**A38 Derby Junctions**  
**TR010022**  
**8.98 Statements of Common Ground**  
**Position Statement**

**Statements of Common Ground Position Statement**

<b>Regulation Number</b>	Rule 8(1)(k)
<b>Planning Inspectorate Scheme Reference</b>	TR010022
<b>Document Reference</b>	TR010022/APP/8.98
<b>Author</b>	A38 Derby Junctions Project Team and Highways England

DELIVERY TRACKS

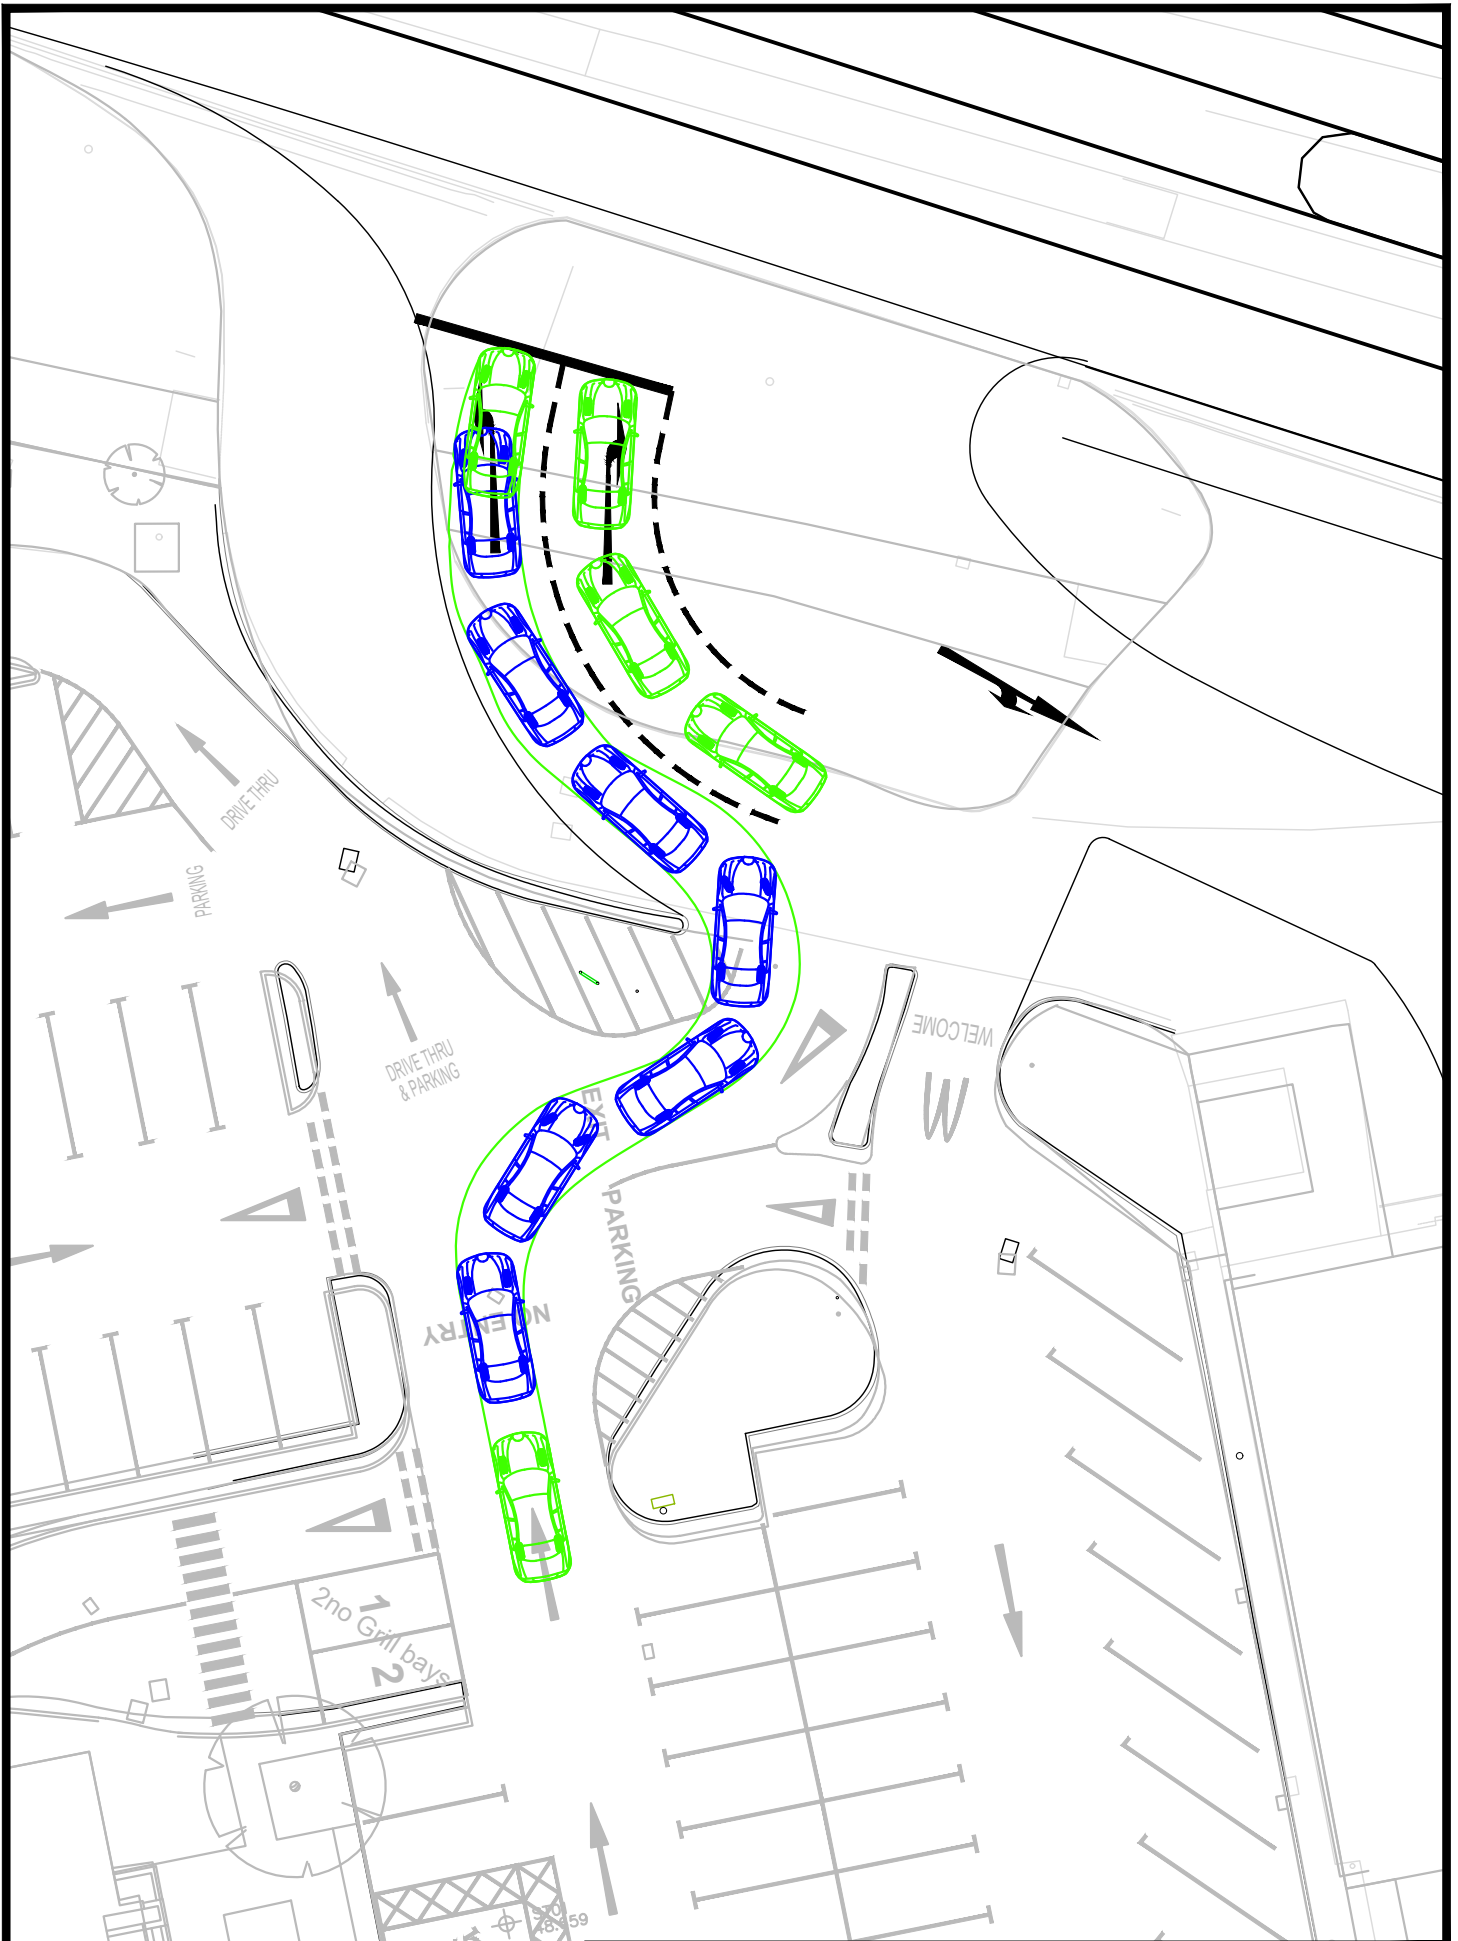
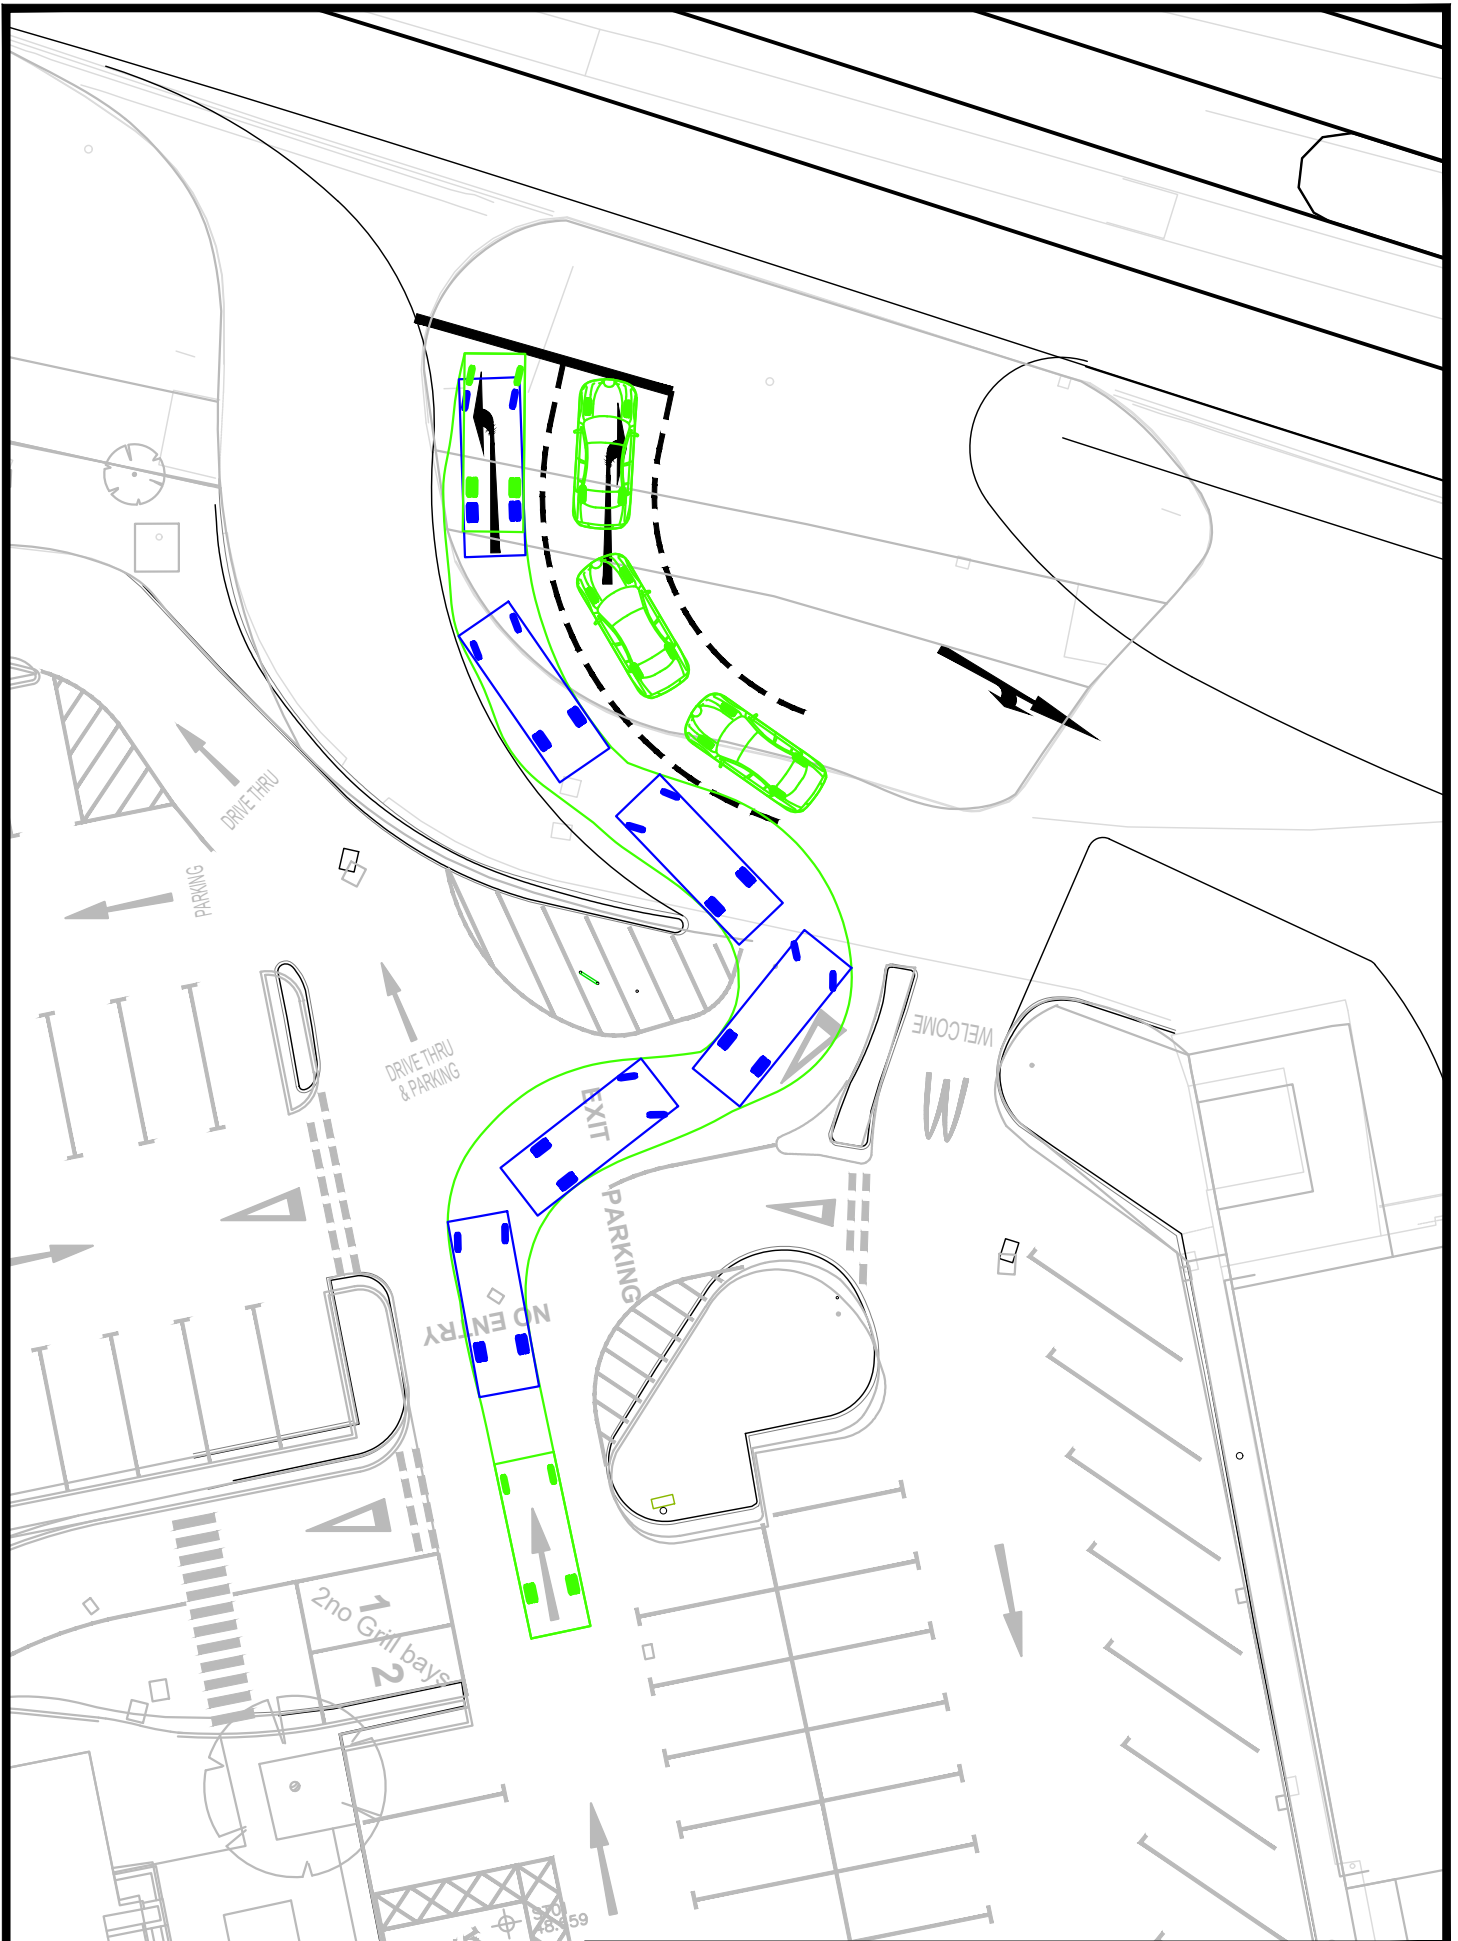
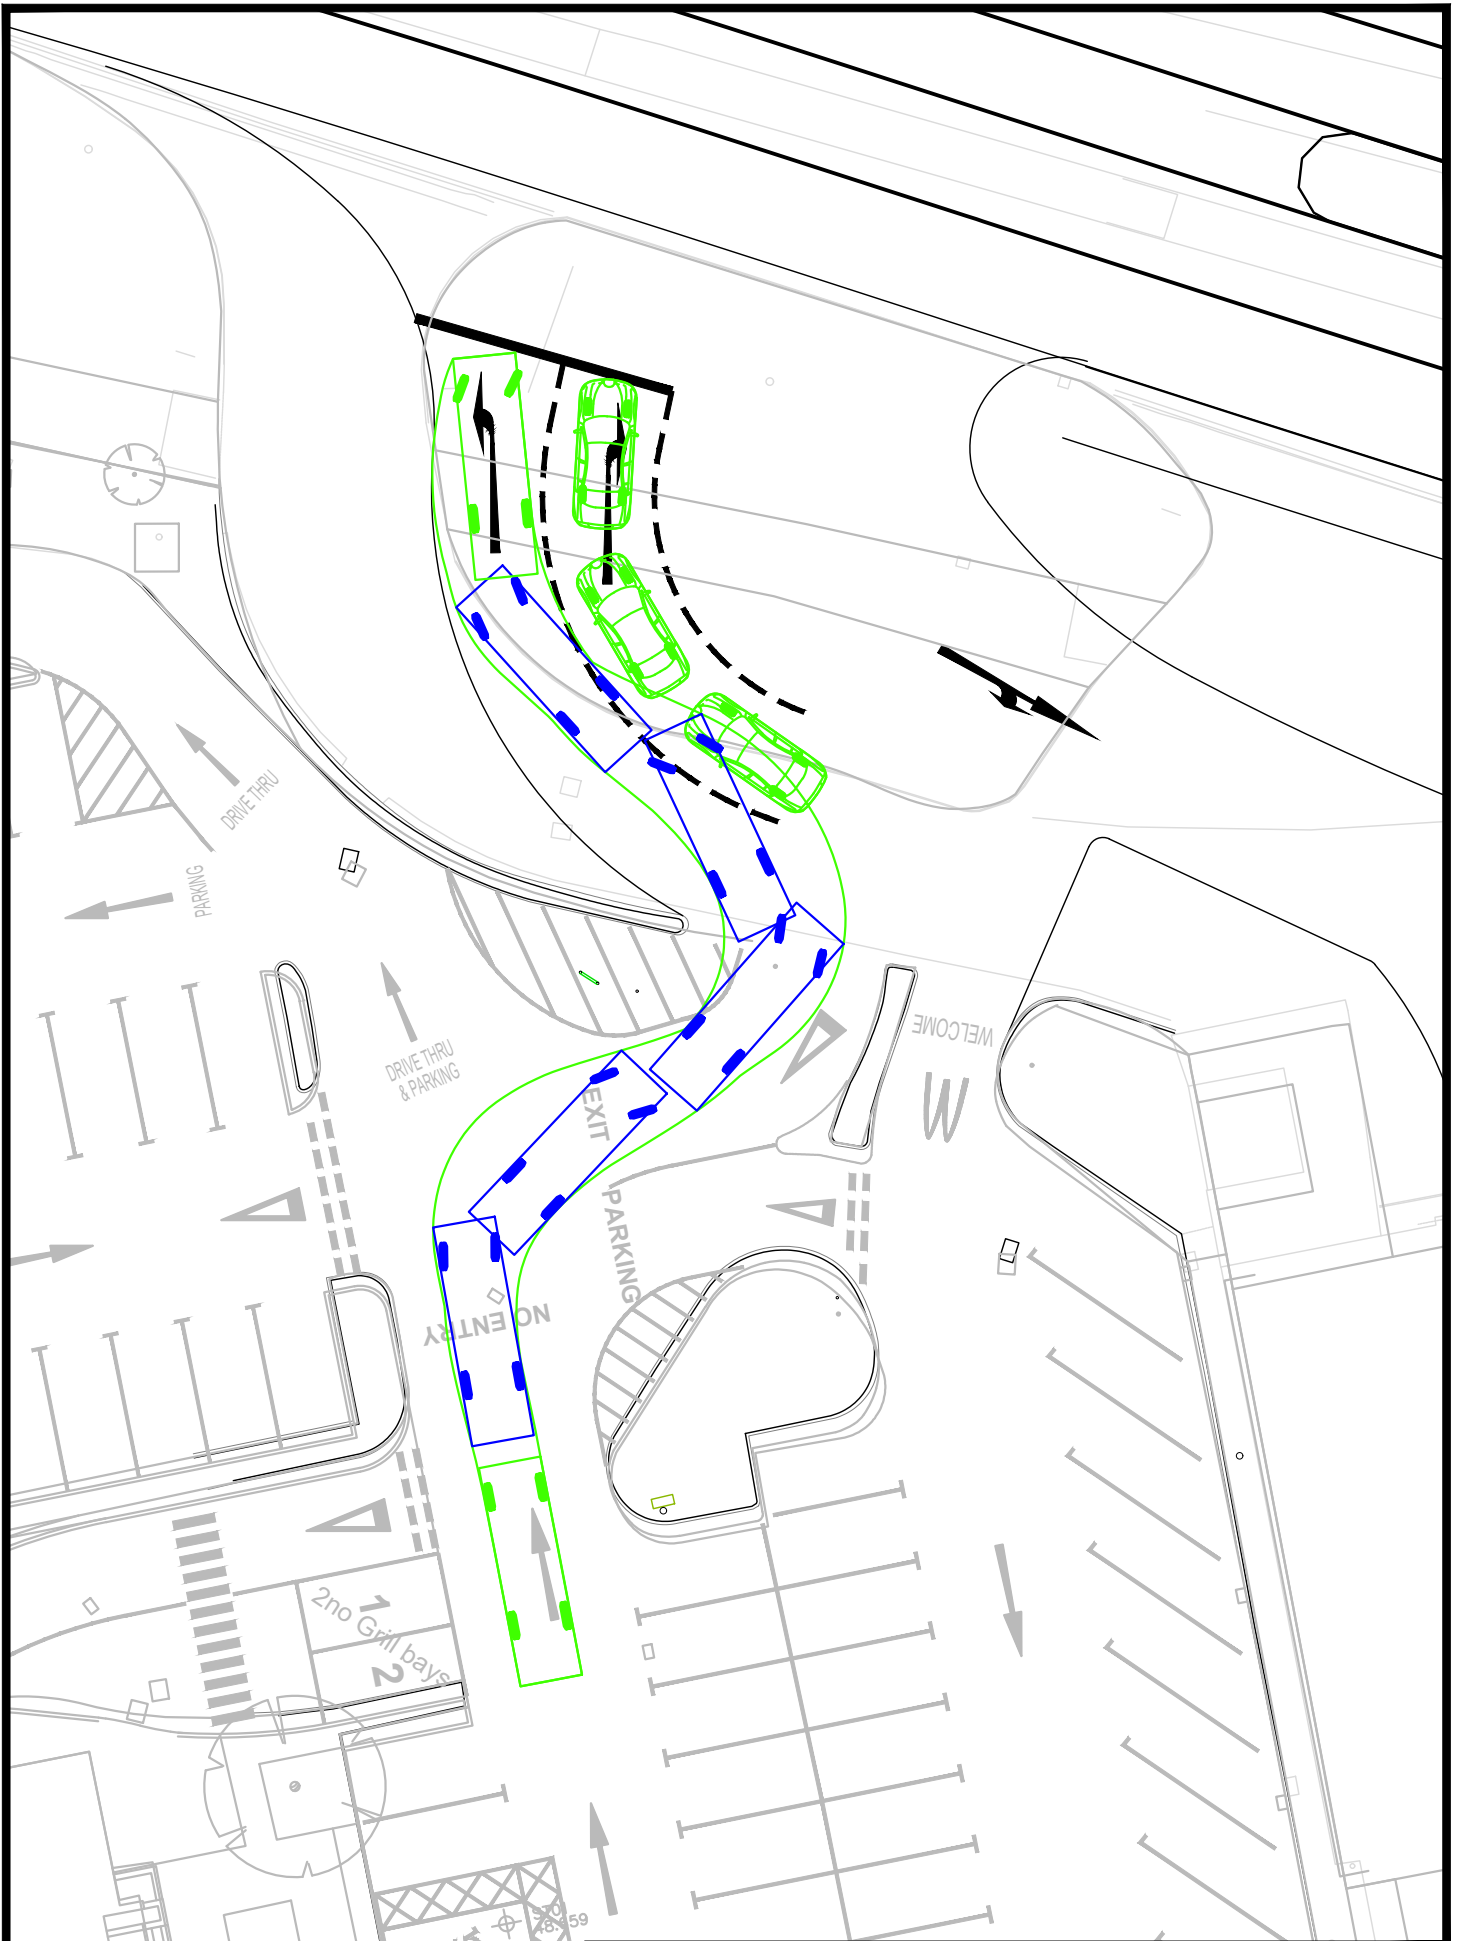
Status	Comment	Applicant's Response and Action
Draft	<p>Currently, deliveries to the Property are received five times per week from the A38 entrance. The Works necessitate a change in delivery routes into the restaurant. The proposed route does not account for how McDonald's delivery vehicles manoeuvre around the Property or potential health and safety concerns. Delivery cages weigh hundreds of kilograms and McDonald's' car park is reinforced in the south part only. By closing the A38 entrance, delivery vehicles will no longer be able to service the Property; they are too heavy to safely cross the unreinforced north section of the Property.</p>	<p>Swept path diagrams have been provided to demonstrate that access for deliveries from the proposed new A52 access is feasible within the current car park layout (and crossing onto the Euro Garages land as they do at present). Highways England has advised that, during the detailed design stage, pavement surveys could be carried out to determine the strength of all parts of the car park with strengthening works carried out as accommodation works if required. Highways England would welcome details of the existing car park construction (strengthened area and non-strengthened area) if available to be able to assess the load bearing capability. At the meeting on the 15th of Jan 2020, McDonald's noted that they have committed to taking core samples in their car park – the resulting information will be shared with Highways England when available. This information has not been provided to date.  <b>ACTION – To be addressed through further joint meeting with McDonalds and Euro Garages during examination phase.</b></p>
